from  
**Southern Water**

**Your ref**  
M/22/25/PL

**Proposal:** Demolition and erection of 1 No dwelling. This application is in CIL Zone 4 and is CIL Liable as a new dwelling.

**Site:** 86 Ancton Way Middleton-on-sea PO22 6JP.

PROPOSED SURFACE WATER DRAINAGE

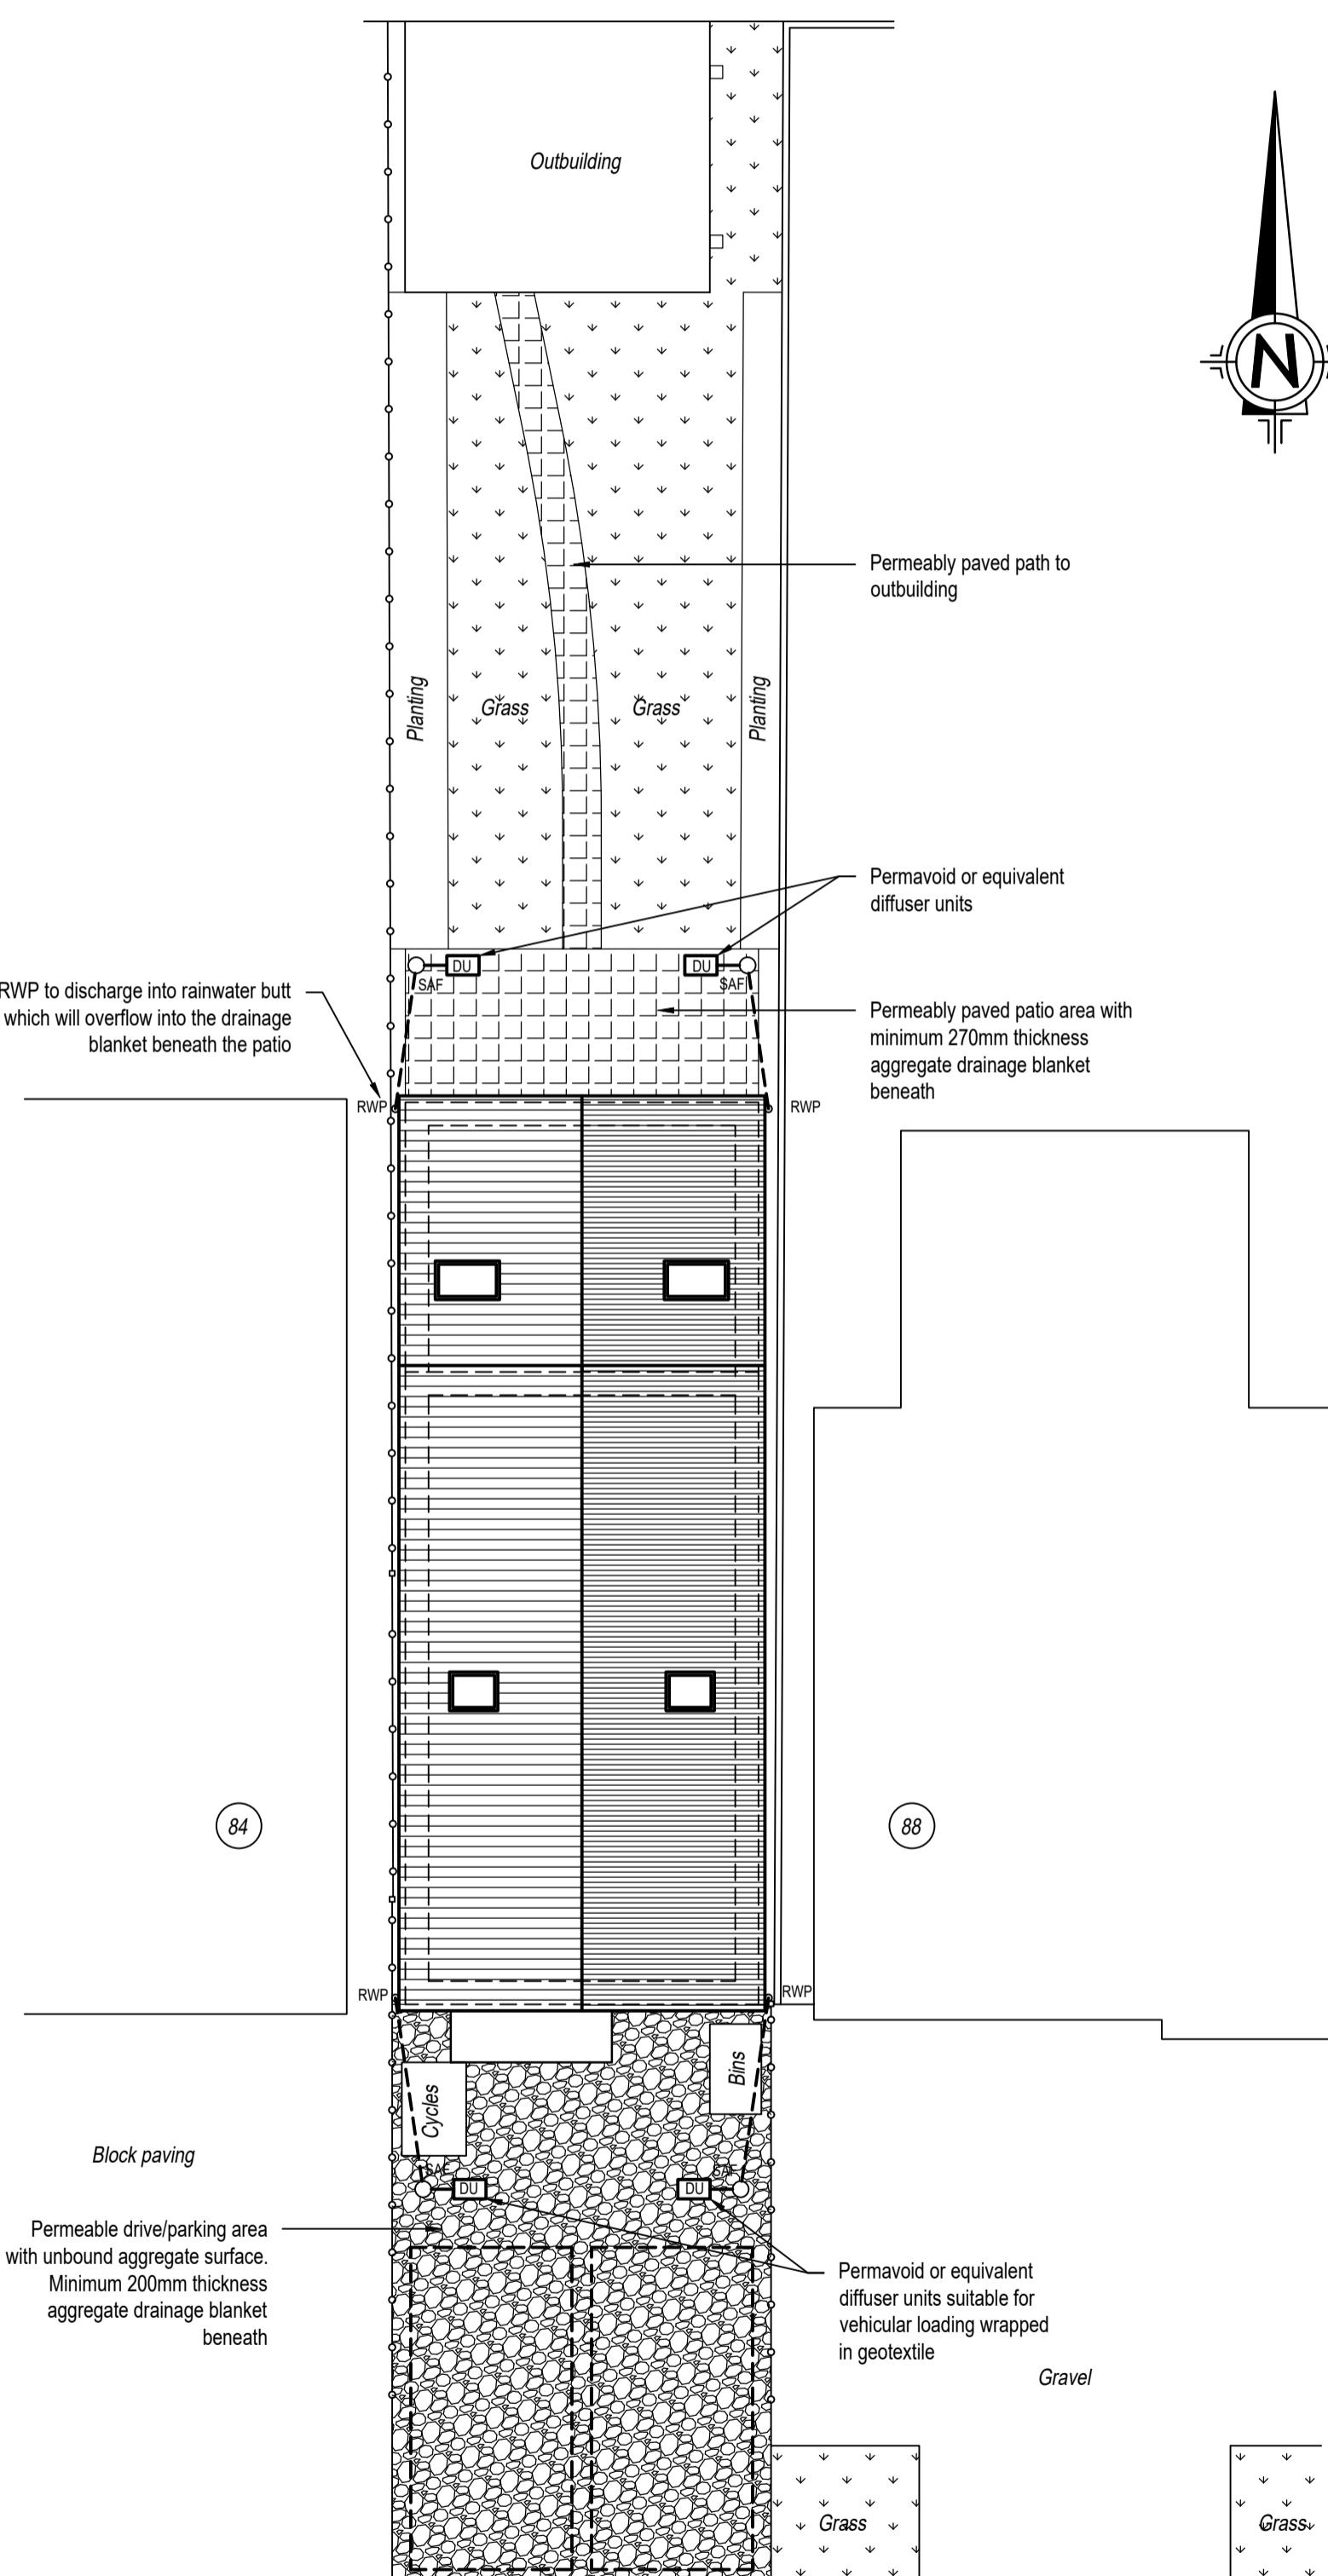
**The supporting documents make reference to drainage using Sustainable Drainage Systems (SuDS).**

Under certain circumstances SuDS will be adopted by Southern Water should this be requested by the developer. Where SuDS form part of a continuous sewer system, and are not an isolated end of pipe SuDS component, adoption will be considered if such systems comply with the latest Design and Construction Guidance (Appendix C) and CIRIA guidance available here:

Where SuDS rely upon facilities which are not adoptable by sewerage undertakers the applicant will need to ensure that arrangements exist for the long-term maintenance of the SuDS facilities. It is critical that the effectiveness of these systems is maintained in perpetuity. Good management will avoid flooding from the proposed surface water system, which may result in the inundation of the foul sewerage system.

Thus, where a SuDS scheme is to be implemented, the drainage details submitted to the Local Planning Authority should:

- Specify the responsibilities of each party for the implementation of the SuDS scheme.
- Specify a timetable for implementation.
- Provide a management and maintenance plan for the lifetime of the development.

Please note that non-compliance with the Design and Construction Guidance will preclude future adoption of the foul and surface water sewerage network on site. The design of drainage should ensure that no groundwater or land drainage is to enter public sewers.
